RE: SSD-82548708 Residential Flat Building with Infill - Affordable Housing-24,26 &28 Middle Harbour Rd Lindfield – 94 Apartments

Please find accompanying the reasons for my objection to this MHR Lindfield Investments Pty Ltd residential development. In addition to this being an inappropriate development for its location with major impacts on surrounding dwellings, there exist a number of inaccuracies in the Environment Impact Statement (EIS).

Drawing Name
Deep Soil Diagrams

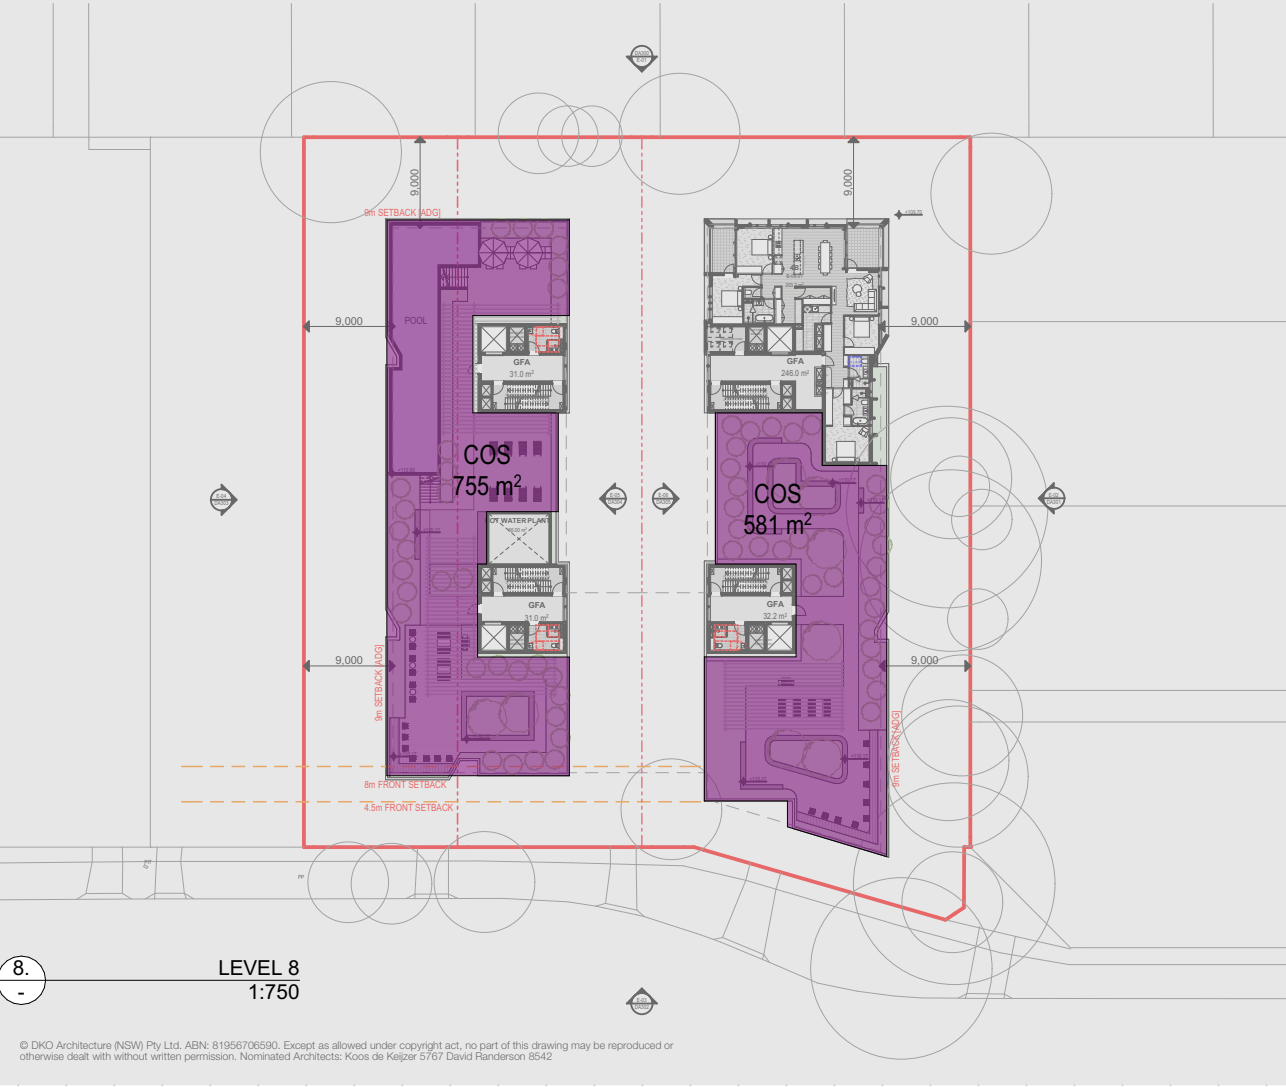
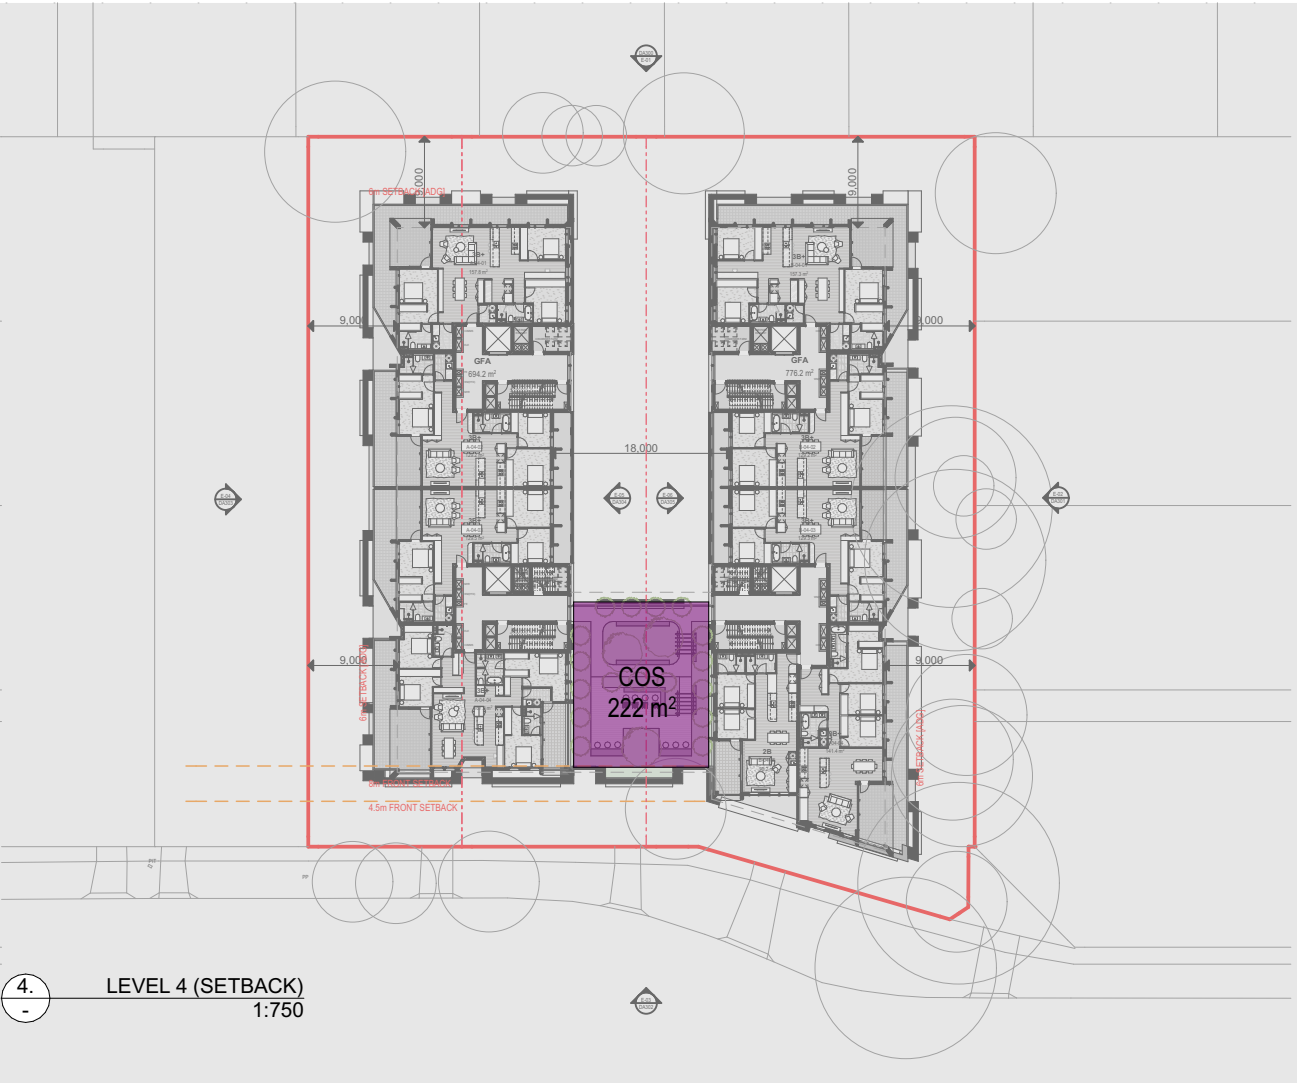
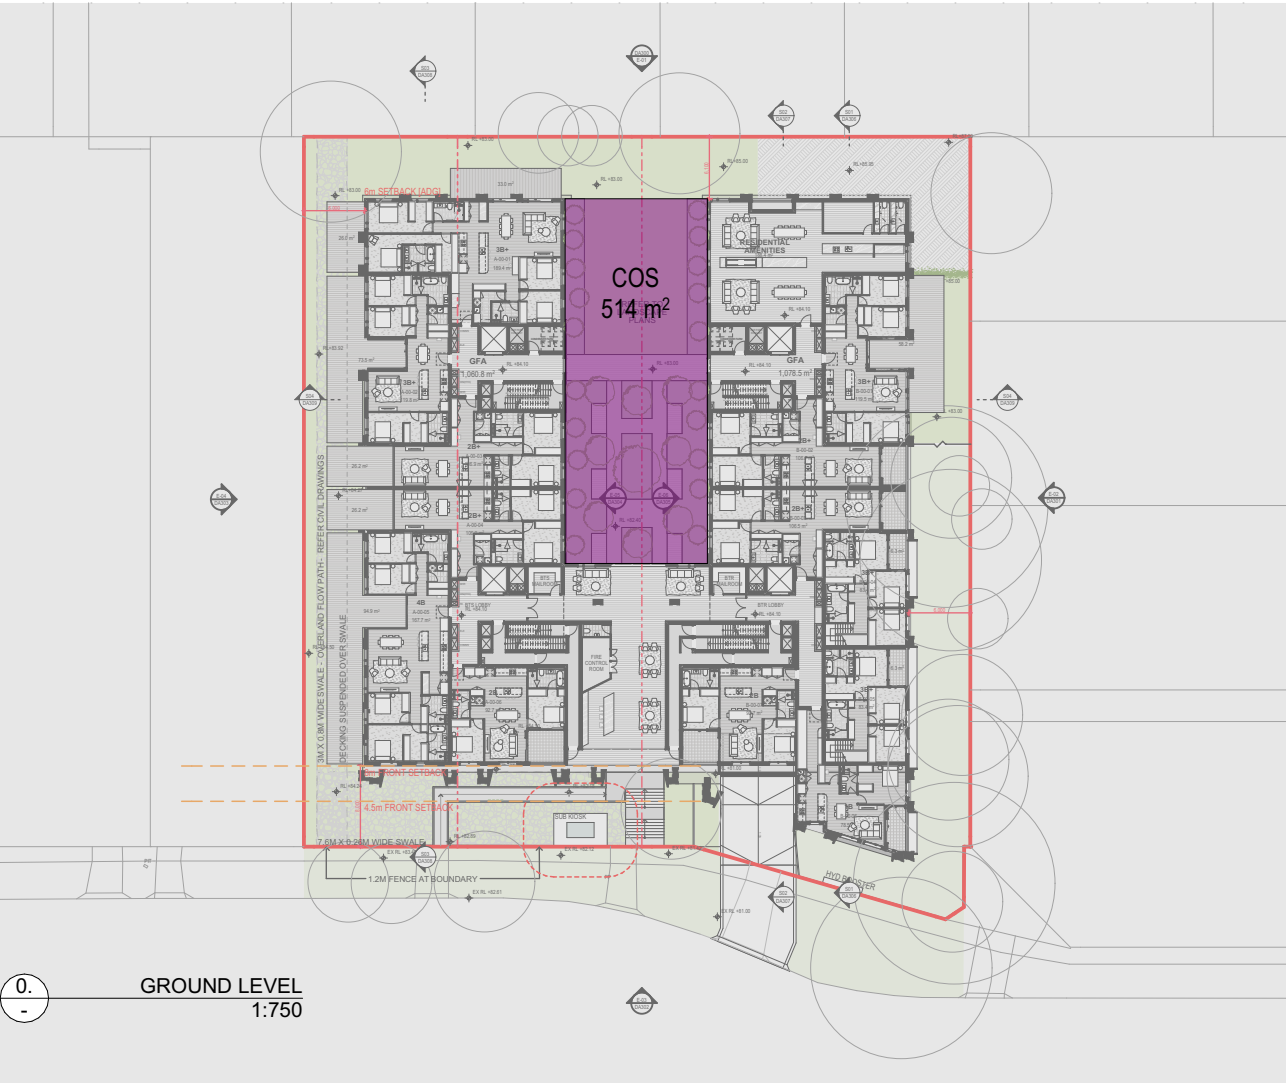
- Deep soil cover should be a minimum of 50%, but is halved to only 28%
- The site is classified to have an FSR of 1.3:1 under the Preferred scenario, not the 3.25:1 of this proposal.
- Its location next to a Heritage Item and Trafalgar Avenue Heritage Conservation Area and its associated requirements are not met.
- The streetscape and strategic context as required in the DCP are ignored
- Communal open space is increased from DCP setting of 10% to a proposed 43% that will impact the noise factor for the immediate vicinity and adjoining properties.

- 3E Deep soil zones- Deep soil of 1383m² (28.3%) will be unlikely to allow for tall tree canopy to develop.
- Housing SEPP requirement for residential flat buildings to provide a minimum of 9m from the side and rear boundary up to the fourth level when located next to lower density residential development are not met.
